CITY OF ALBUQUERQUE

January 24, 2022

Re: Chase Bank – US 66 & Coors Remote ATM
111 Coors NW, ste E-11
Traffic Circulation Layout
Engineer's/Architect's Stamp 12-10-2021 (K10-D018A)

SITE PLAN

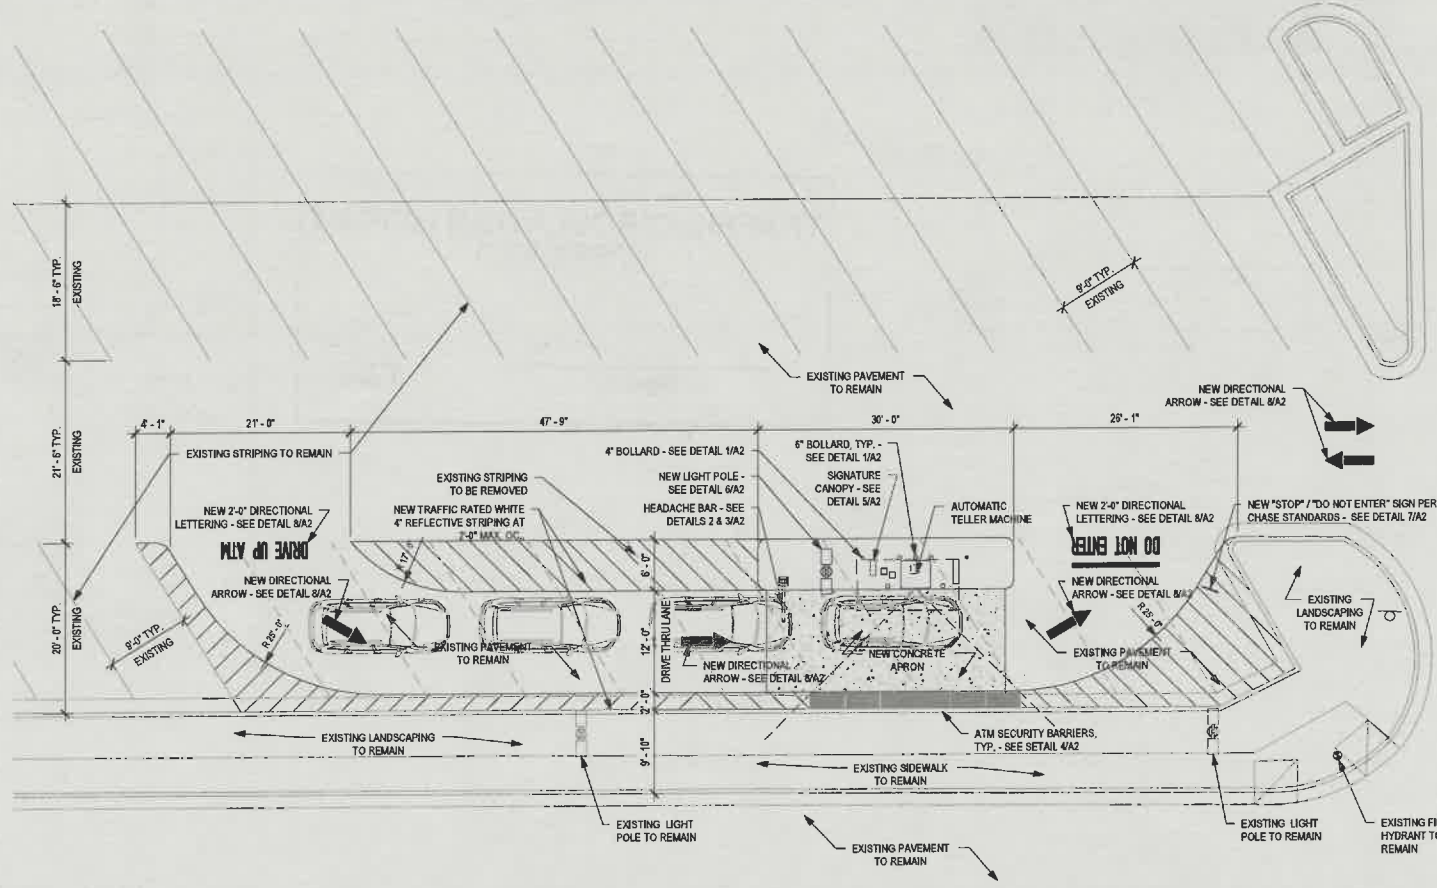
1. Drive Aisle adjacent to egress of drive thru:

- Please provide a large arrow to define drive aisle orientation and provide Arrow details for this pavement markings.

2. Provide color of text for the proposed DO NOT ENTER, DRIVE UP ATM, and ARROW (size/dimension and color) text.
3. The minimum drive through lane width is 12 feet with a 25 foot minimum radius (inside edge) for all turns. (A 15 foot radius can be used with an increase in lane width to 14 feet). Please dimension all lane widths and radii.
4. Shared Site access: driveways that straddle property lines, or are entirely on one property but are to be used by another property, shall have an access easement. Please include a copy of your shared access agreement with the adjacent property owner.
5. Please provide a letter of response for all comments given.
